From: Christopher Ashworth [mailto:CAshworth@cityofsydney.nsw.gov.au]
Sent: Wednesday, 17 June 2015 4:47 PM
To: Brendon Roberts
Cc: Amy Watson; Natasha Ridler
Subject: North West Plot, Darling Square, Darling Harbour (SSD 6013 MOD 1) – Response To Submissions

RE: NORTH WEST PLOT OF DARLING SQUARE, DARLING HARBOUR (SSD 6013 MOD 1) – RESPONSE TO SUBMISSIONS

I write in relation to the Department’s email dated 2 June 2015 which referred to Response to Submissions regarding State Significant Development Application SSD 6013 MOD 1. This proposal is for modifications to the North West Plot at Darling Square.

DEVELOPMENT APPLICATION  
 NORTH WEST PLOT  
 GROUND FLOOR PLAN

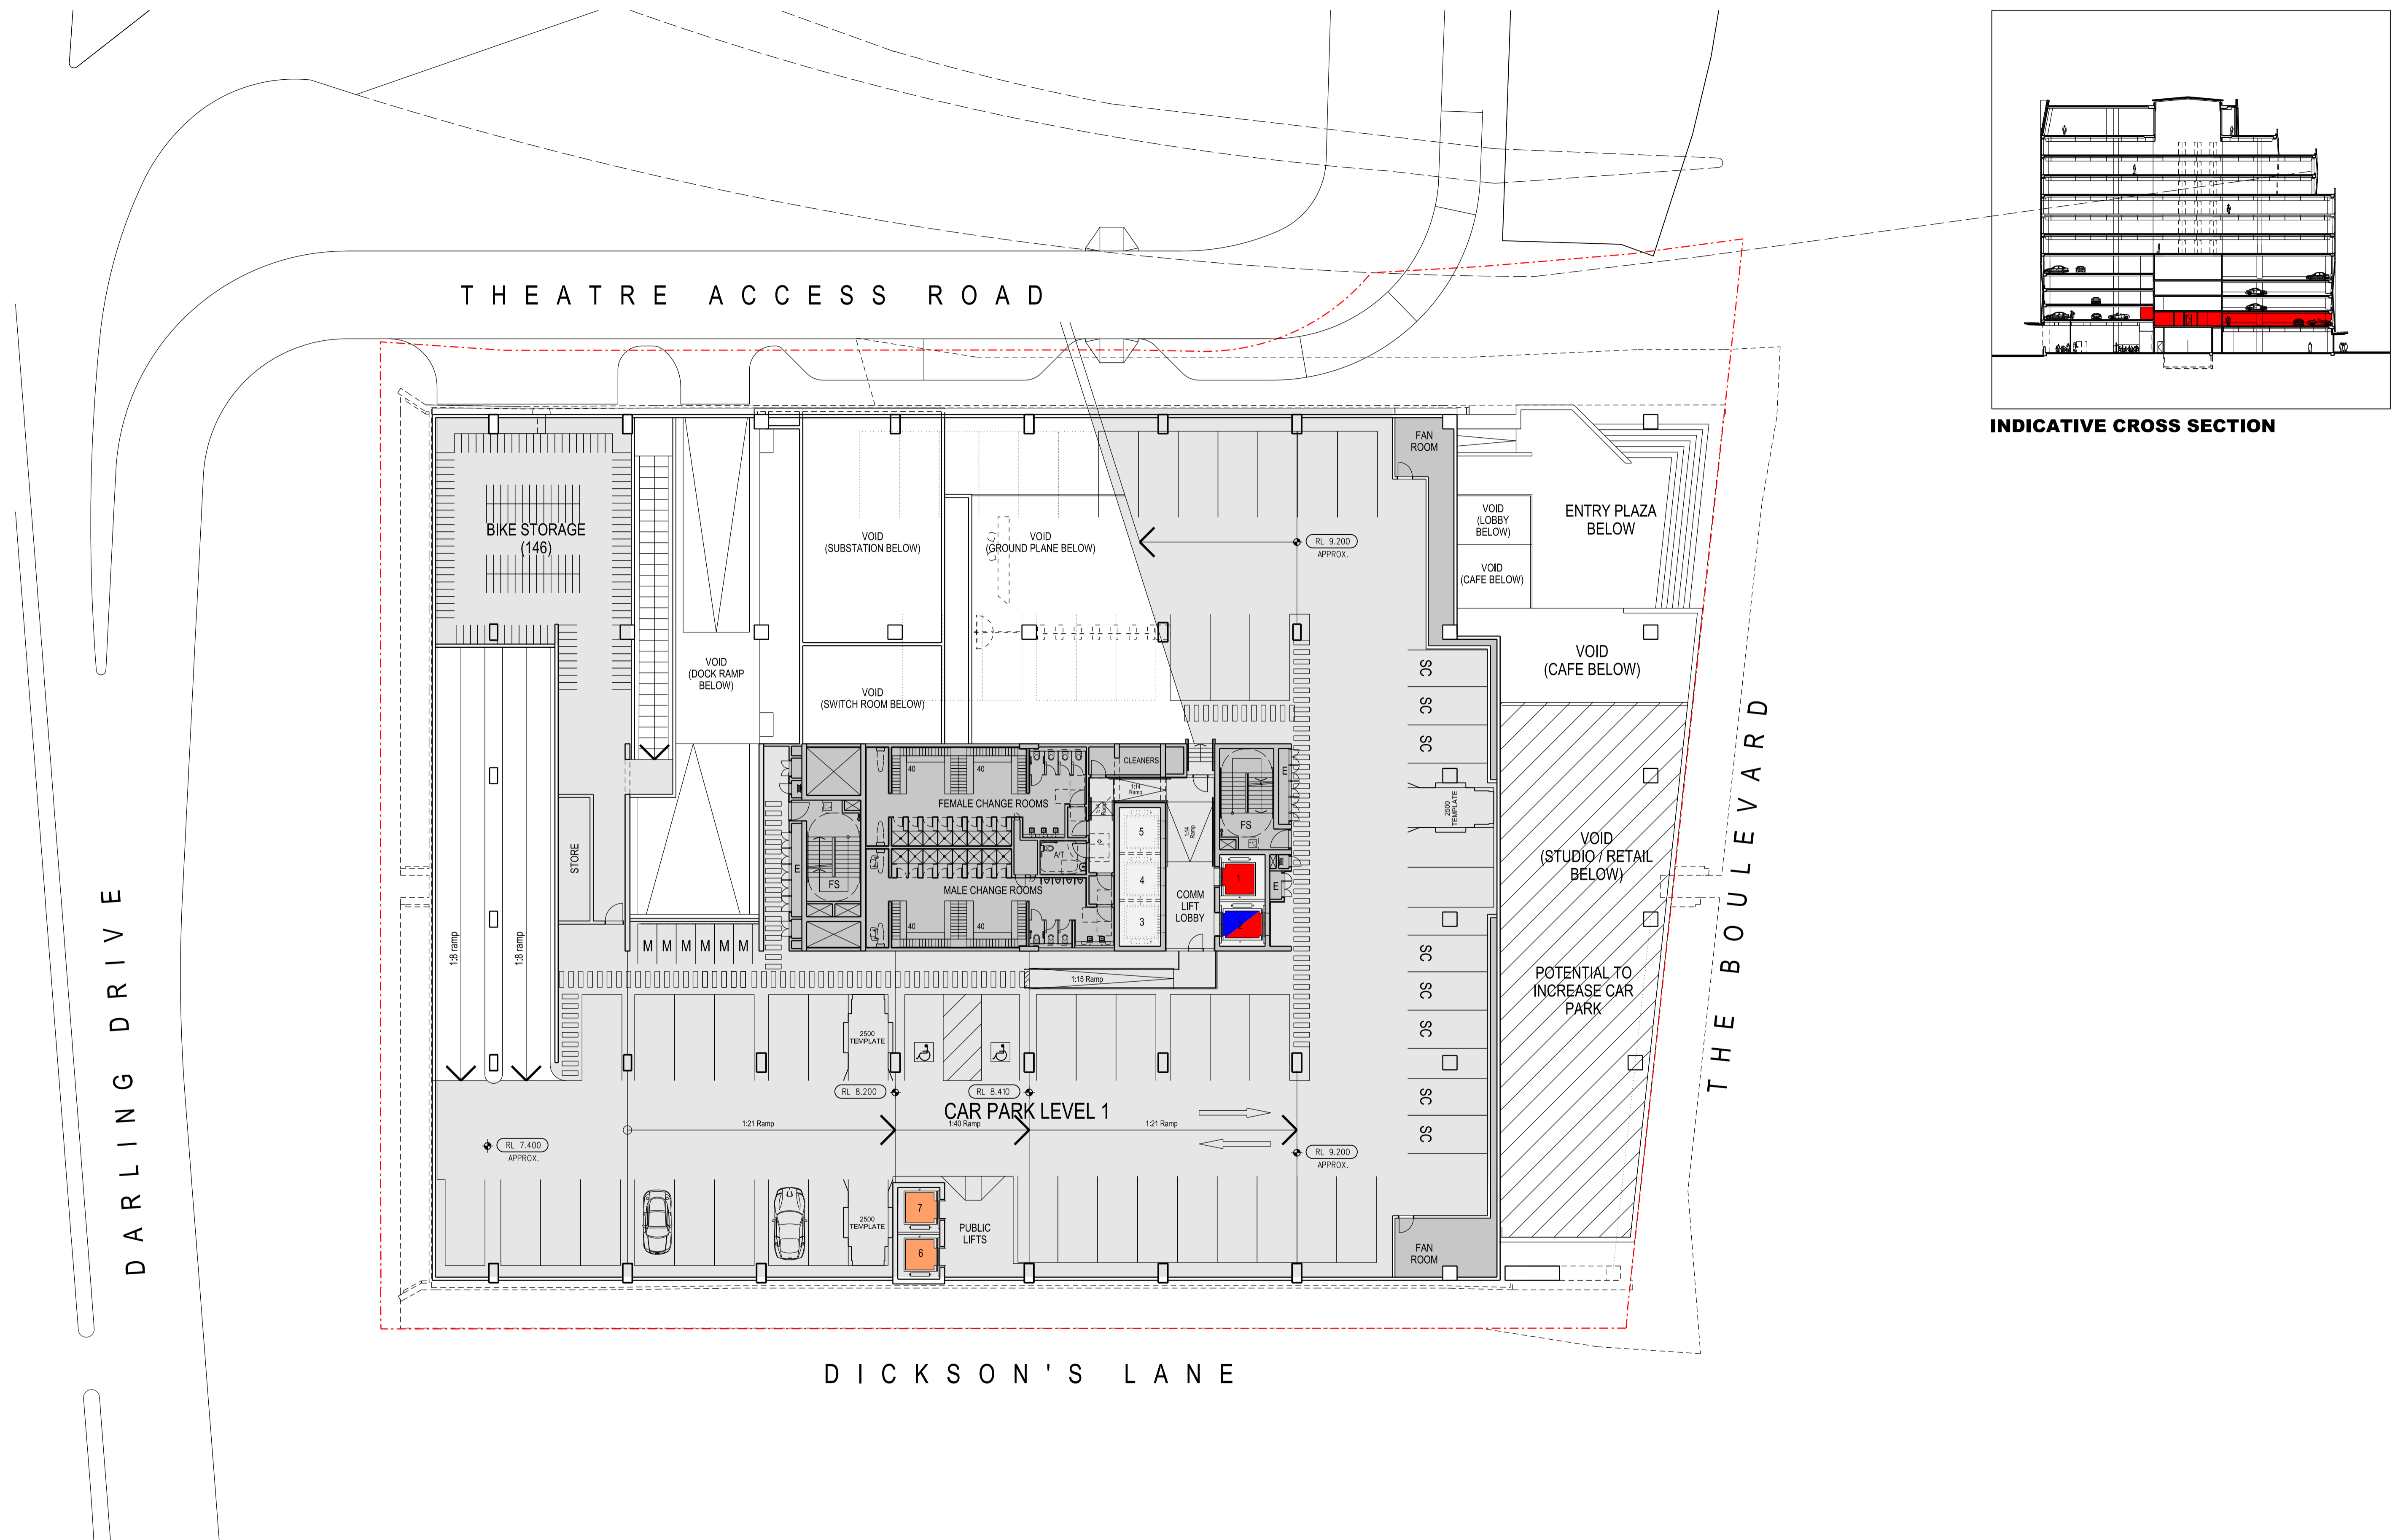
Issue	Applicant’s Response	Issue Addressed?	City’s Contention
Active Frontages			
<p>It is recommended that the ground floor layout be amended in order to increase activation of the northern frontage by redistributing some of the services and inactive functions.</p>	<p>The ground floor of the proposal has been further modified to increase activation, particularly along the northern boundary. The configuration of retail tenancies has been slightly amended and the northern elevation has been enhanced with an altered outdoor dining space and stairs. The internal reconfiguration and reshaping of the ground floor, as well as efficiencies in plant design, has allowed for an additional 359m2 of active uses GFA to be accommodated on the ground level.</p> <p>The north-eastern corner of the building has been extended north to highlight and further activate this important corner.</p>	<p>No</p>	<p>The northern elevation remains substantially inactive. The amended design does not incorporate entrances to the building lobby or retail spaces from the northern facade.</p> <p>The proportion of the northern frontage accommodating back of house facilities, services, and vehicular access remains unchanged.</p> <p>Whilst the back of house facilities have been reconfigured, the result is the private benefit of a larger retail tenancy fronting Dickson’s Lane, rather than a public benefit of activation of the northern facade.</p> <p>It is also noted that the reconfigured tenancies and services do not provide direct access</p>

between the loading and waste facilities and the IQ Hub and south-eastern retail tenancy.
Wall Advertising			
The City objects to the increase in the signage zone above what has already been approved. Secondly, the sign should be positioned to align with the composition of the panels and the metal cladding of the northern facade.	The wall advertisement illustrated on the northern elevation has been relocated and sized to be consistent with the approved extent of the advertisement, rectifying the original drafting error on the submitted drawings.	Yes	N/A
Gross Floor Area			
It is recommended that the proponent submit a tally of all currently approved and proposed GFA across the areas subject to the Concept Plan approval. This is to ensure that the overall Darling Square development can be delivered in accordance with Condition A8 of Development Consent SSD-5878, which states inter alia, that a maximum of 49,545m2 of non-residential GFA is permitted.	A section 96 modification is currently being prepared to increase the maximum non-residential GFA under the approved Stage 1 Concept Proposal (amongst other things). This modification will ensure that the vision for Darling Square can be fulfilled both in terms of approved building envelopes and the achievement of a vibrant and active mixed use precinct. In light of the impending modification, the future GFA is unable to be provided at this time as the final provision is still being resolved.	Yes	N/A

Figure 2.01 : Section 96 NW Plot Ground Plan Design Proposal

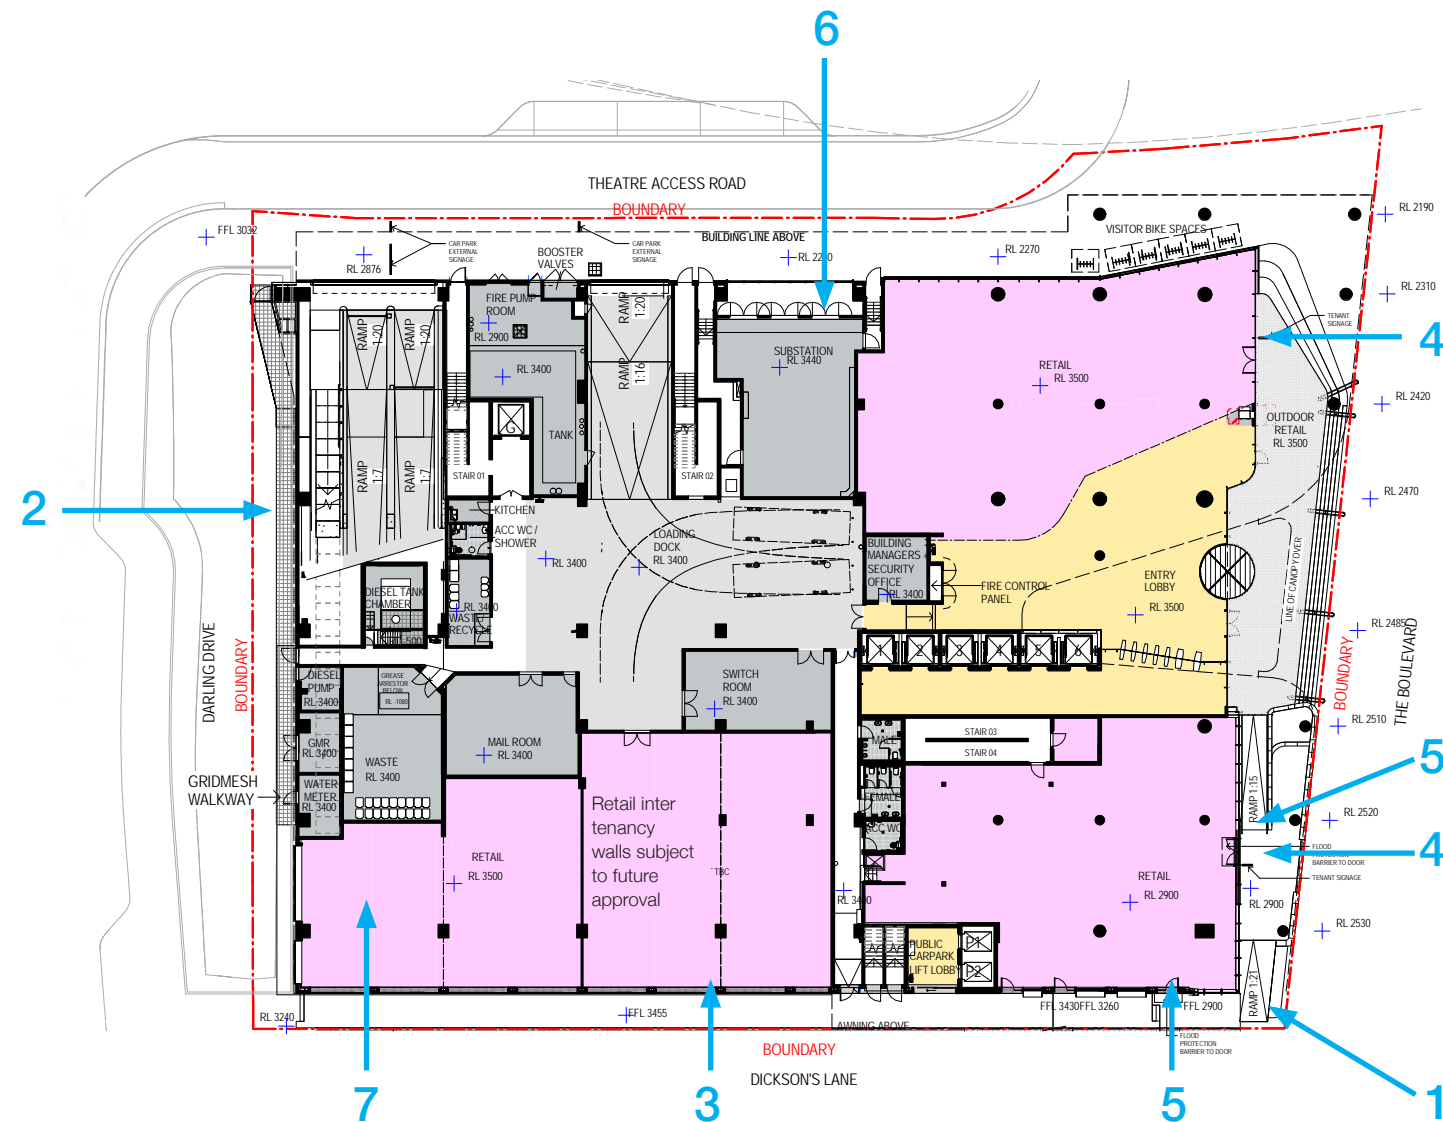
The area outside the north-east retail tenancy and the building lobby is now nominated as an 'outdoor retail' area, which may possibly be a reference to an outdoor dining area. The suitability of this location for outdoor dining is questionable, as this is likely to be a high traffic area adjacent to the main access/egress point in the building. Further information about the type and extent of the proposed activities should be obtained before granting development consent.

Additional information should be sought with regards to the proposed treatment of the area in-between the external columns at the south eastern corner (illustrated in white below). There may be an opportunity to incorporate landscaping or high quality finishes in this area appropriate to the location, being the building's principal frontage.
